## WEST SUSSEX COUNTY COUNCIL CONSULTATION

| <b>LOCATION:</b>                | Old Barn Free House 42 Felpham Road Bognor Regis<br>PO22 7DF                                                                                                                                                                        |
| <b>SUBJECT:</b>                 | FP/14/22/PL<br>Change of use: Ground floor of former pub to be annexed to provide downstairs living area of existing residence (resubmission following FP/209/20/PL). This site is in CIL Zone 4 and is CIL Liable as new dwelling. |

Proposed Floor Plans and Elevations

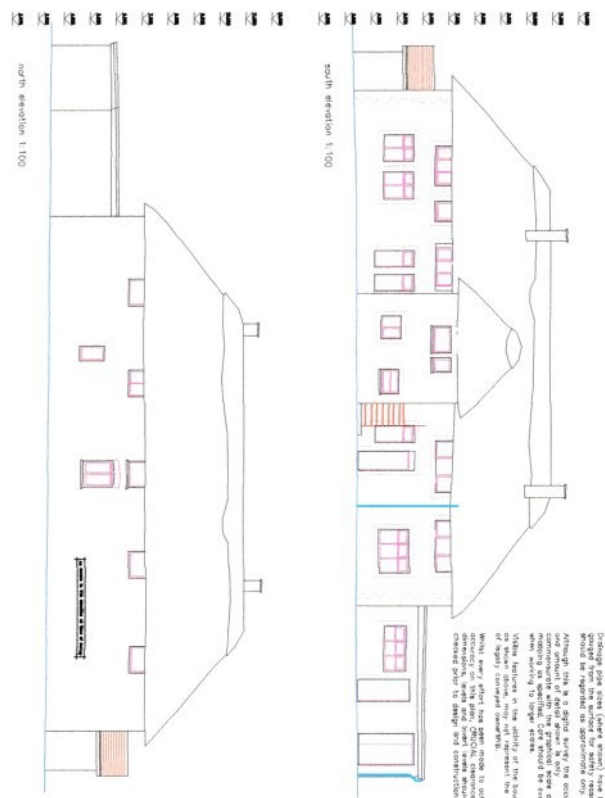
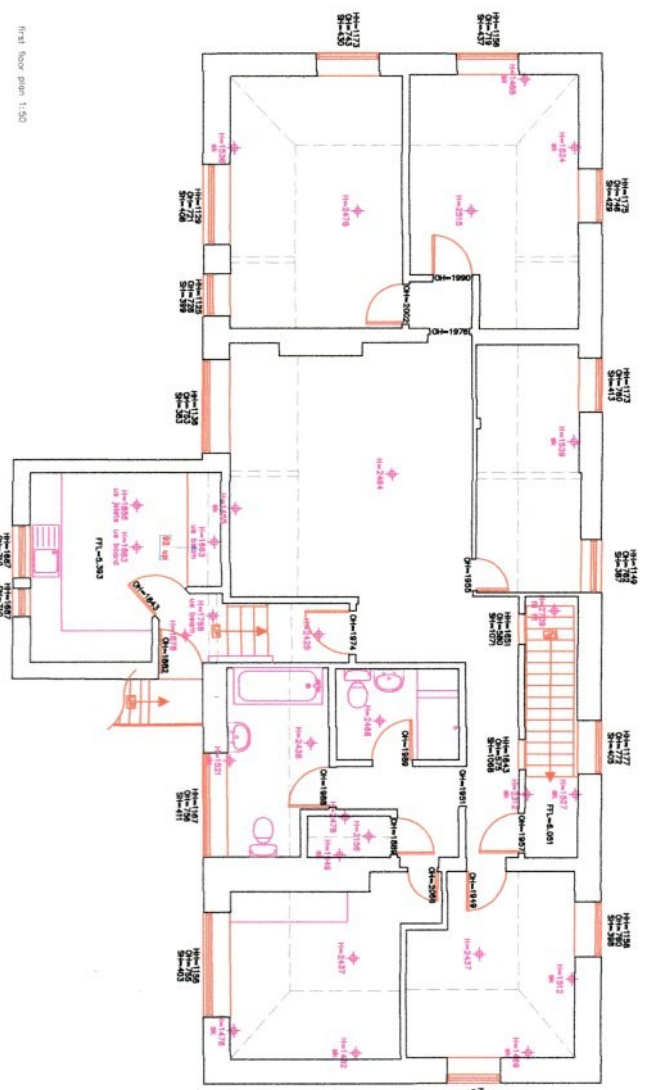
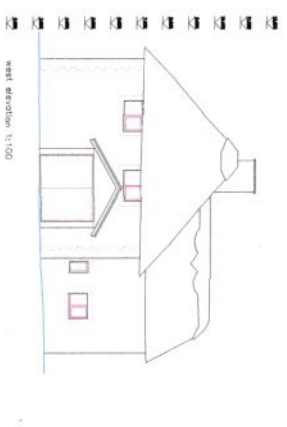
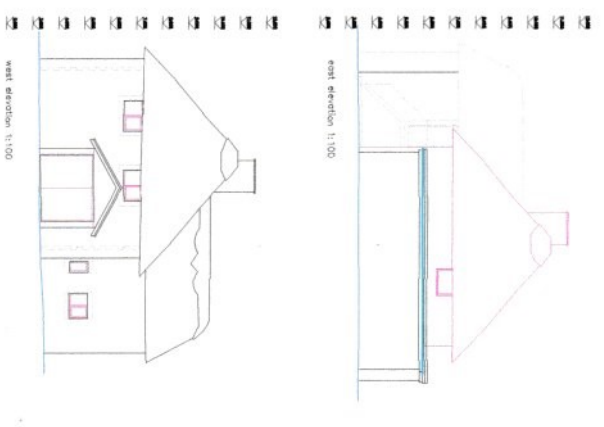
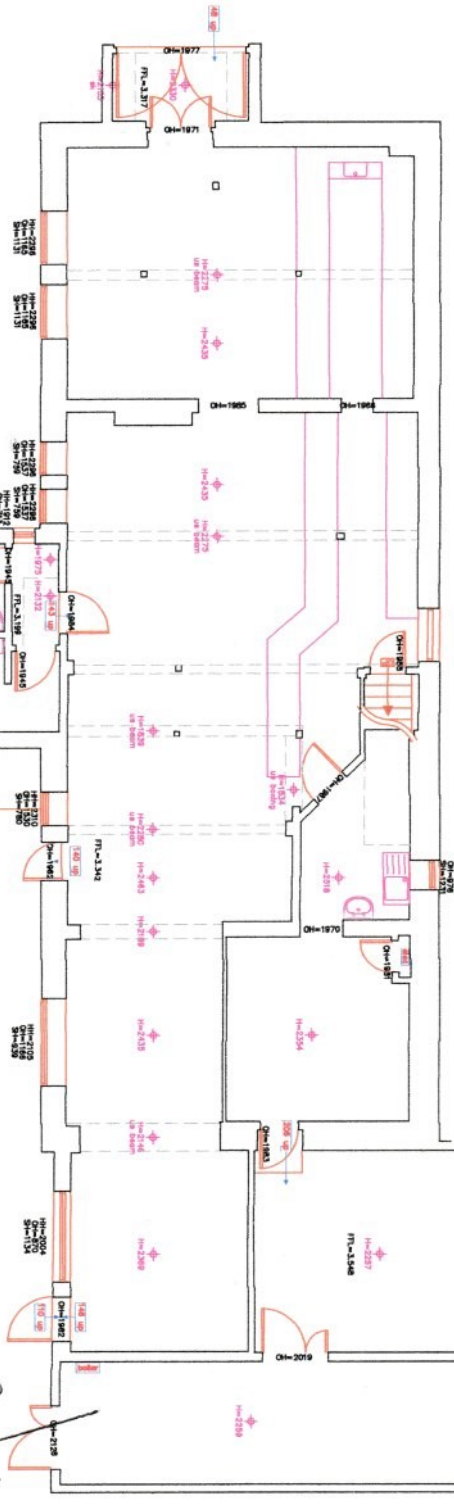
The existing flat at the first floor contains 5 bedrooms, and the proposed ground floor conversion would provide additional habitable space, but no further bedrooms are proposed. The application form indicates that two parking spaces are currently provided on site and will be retained for the proposed enlarged dwelling. The proposed plans do not demonstrate the location of parking, however, the LPA anticipate that this will be provided within the existing parking area visible on local mapping, accessed from Barn Feld. Additional parking provision is available on the other side of Barn Feld within the applicant's land.

Secure and covered cycle storage is proposed within the existing outbuilding.

If the LPA are minded to approve the application, a condition securing the cycle storage is advised.
